Your ref
Our ref PG/EVP/WS/3/12/8293 & 3/12/8283
Date: 29 September 2011

**APPLICATION NUMBERS 3/2011/0477 AND 0621
PLANTATION FARM, CHIPPING ROAD, CHAIGLEY
GRID REFERENCE SD 665 430**

320110477P

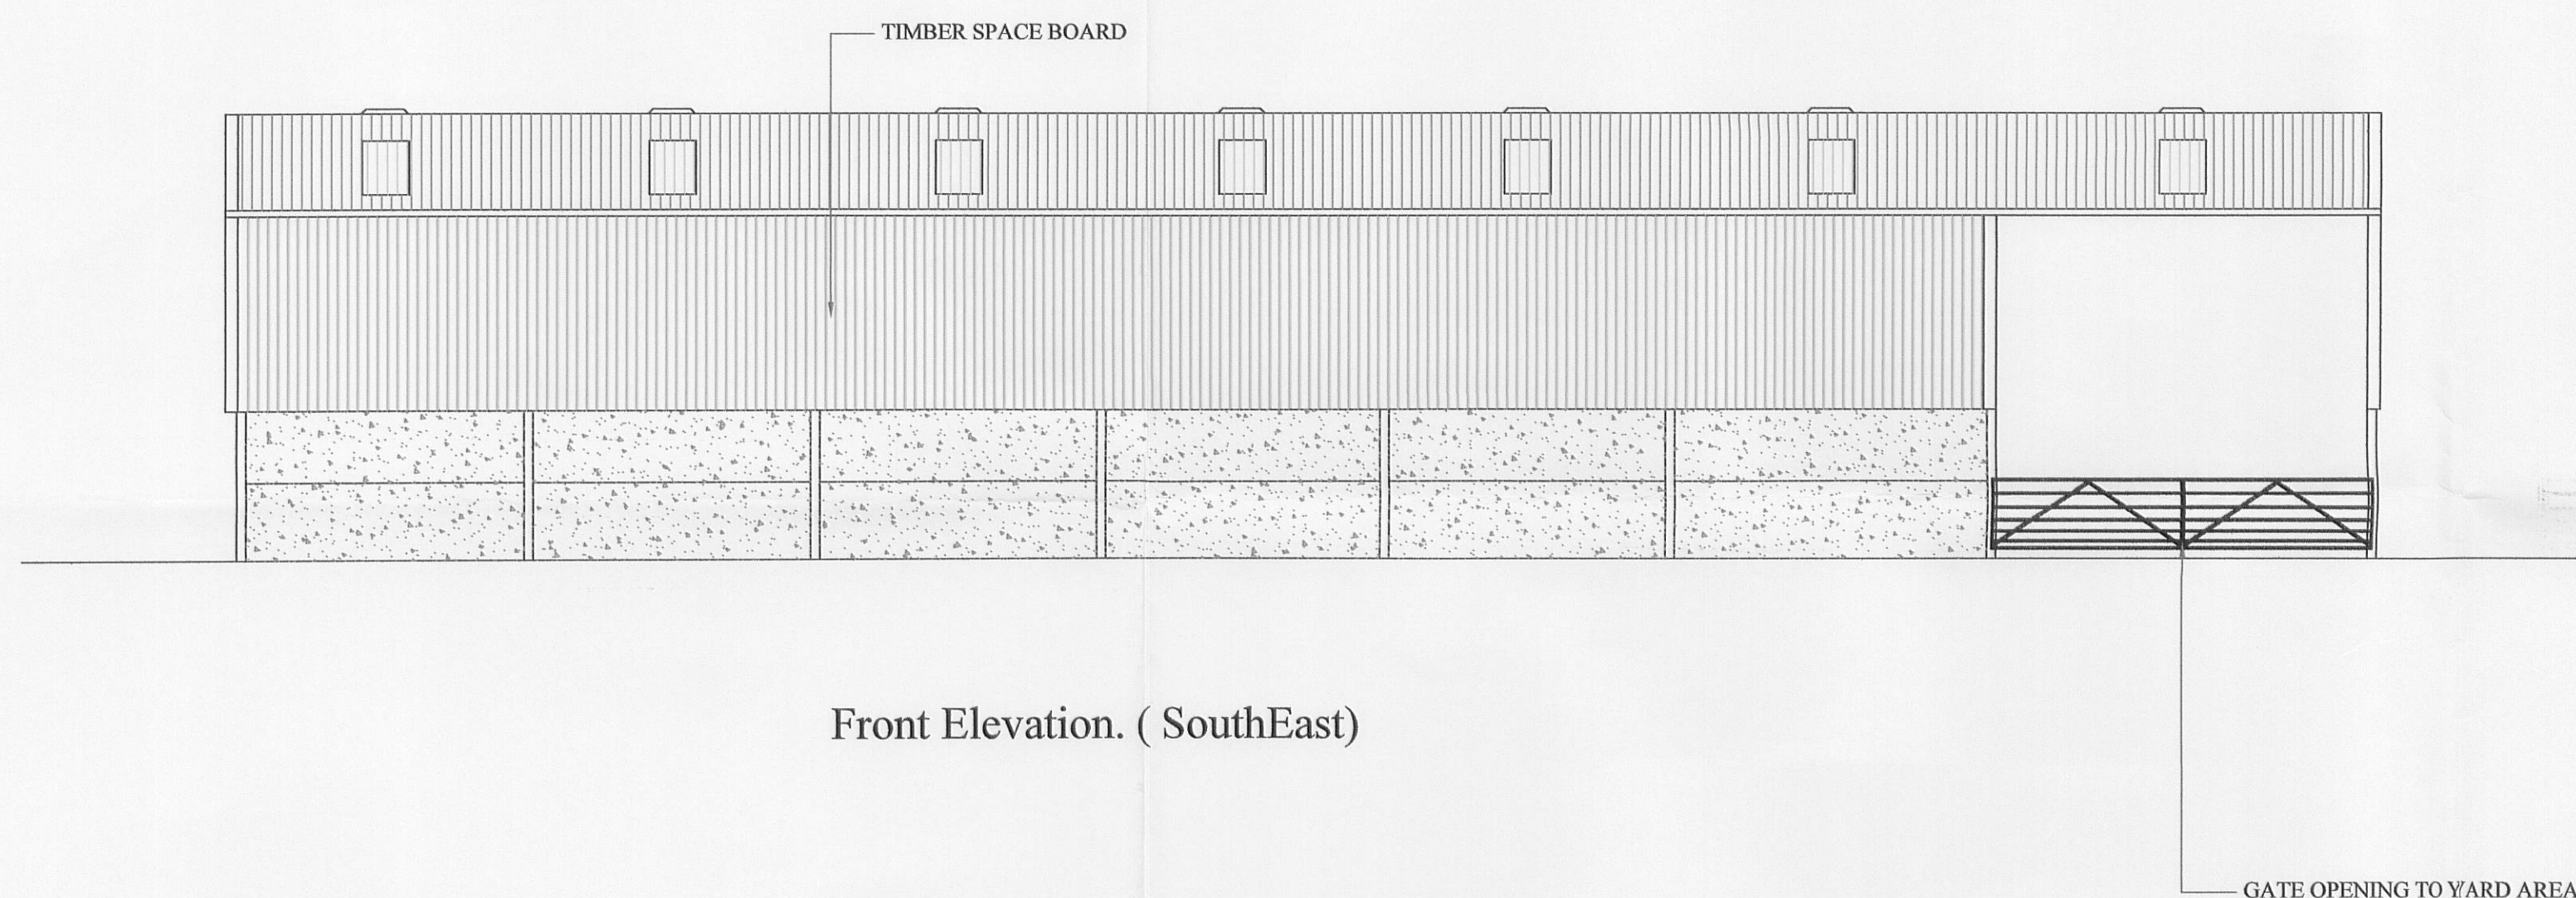
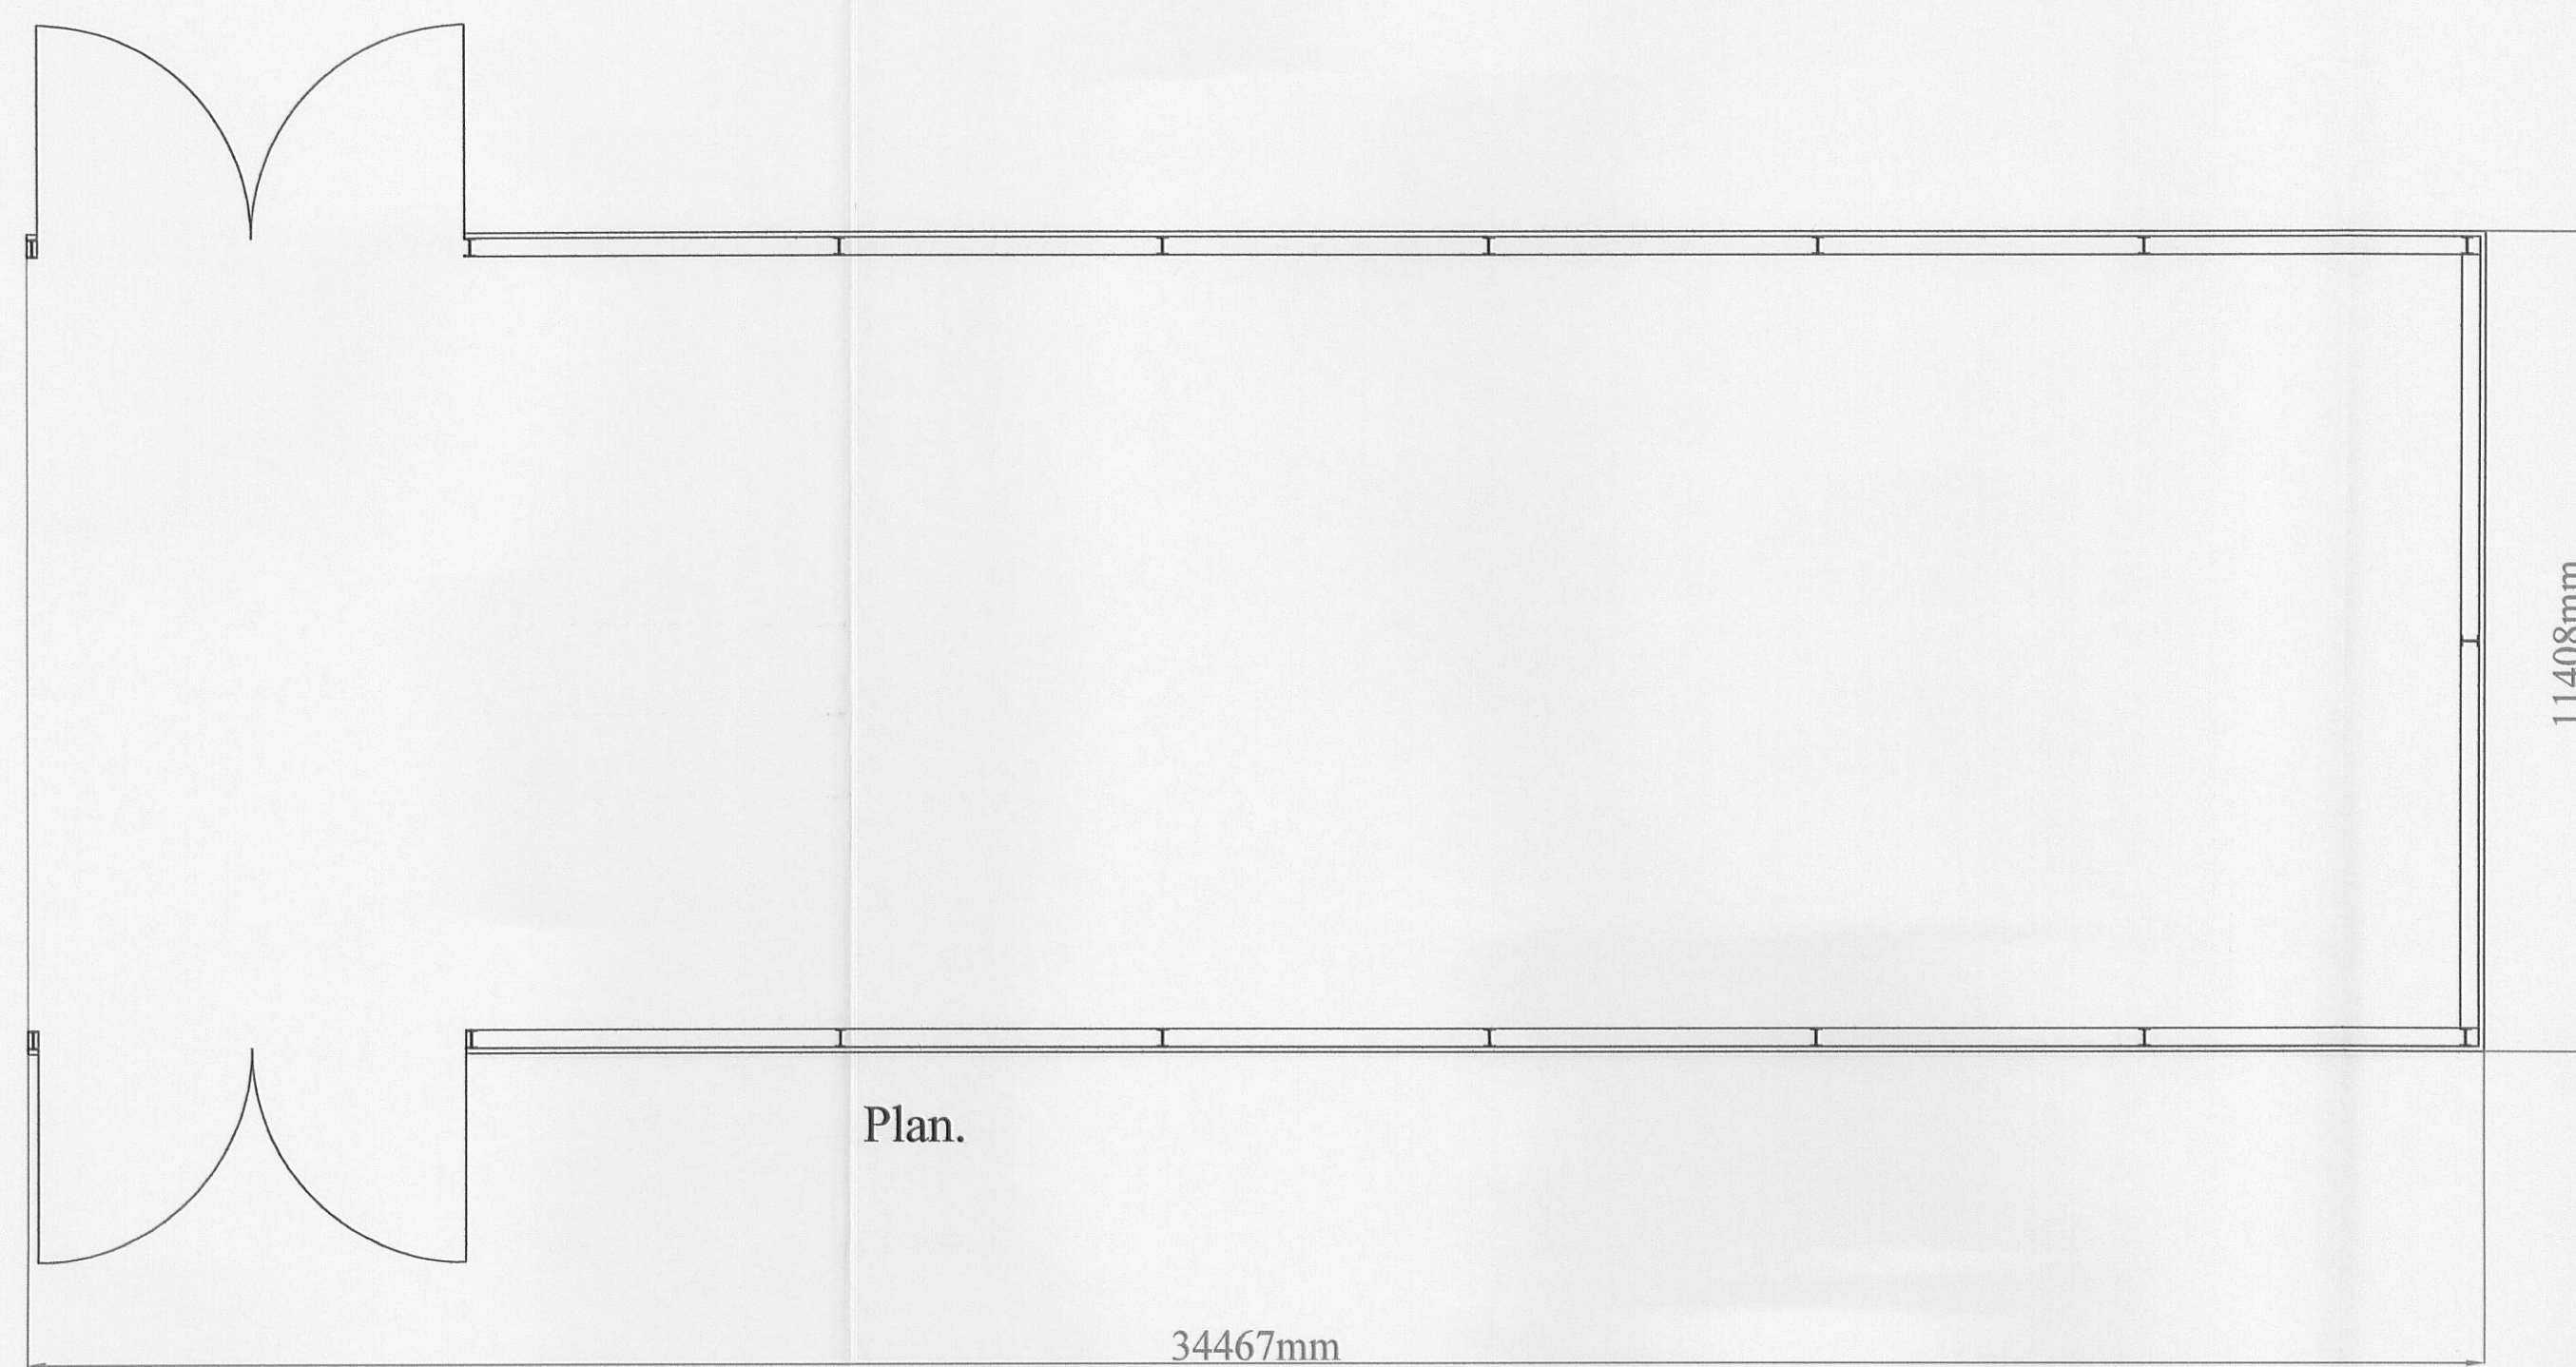
The building is of a purpose built agricultural type design, and is roofed to prevent rain water from entering the store.

I consider the size of the building to be acceptable, but only on the basis that the proposed expansion in livestock numbers takes place.

SITE PLAN

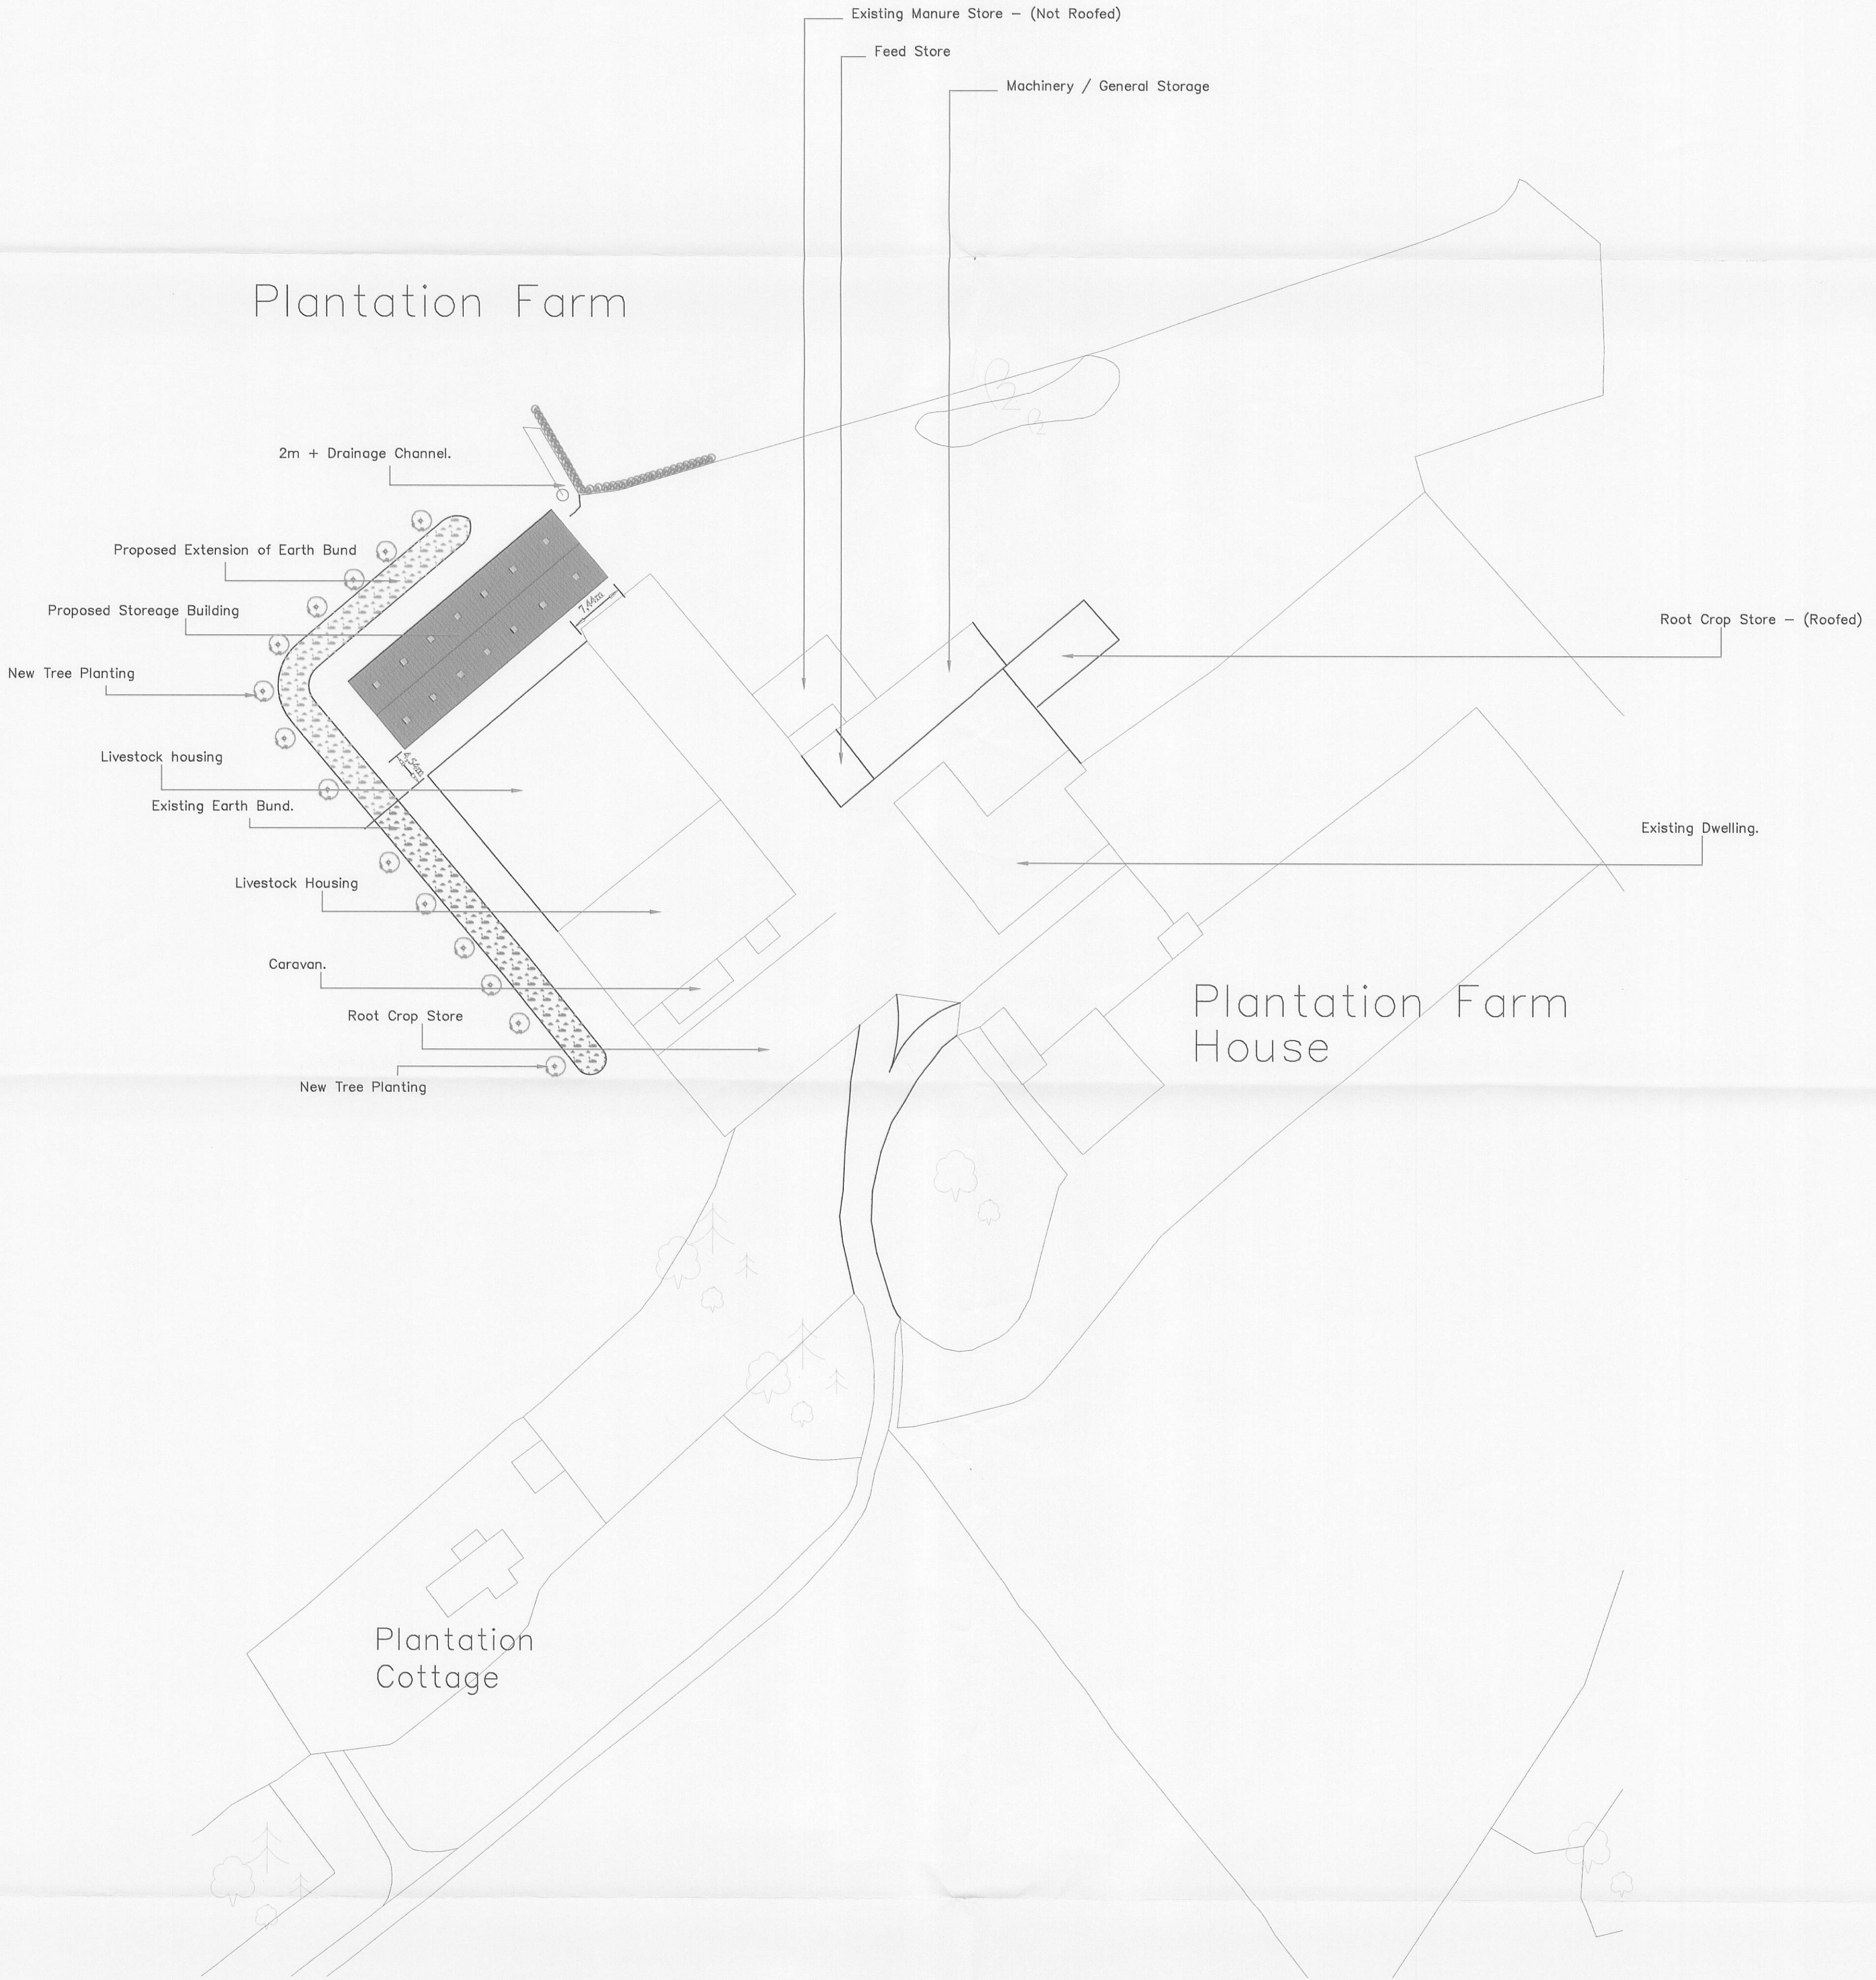
The proposed site of the covered midden is adjacent to the existing livestock buildings, which will facilitate ease of waste management. I therefore consider it to be appropriate. The proposed general storage building is also within close proximity to the existing buildings, and is also suitable from an operational point of view.
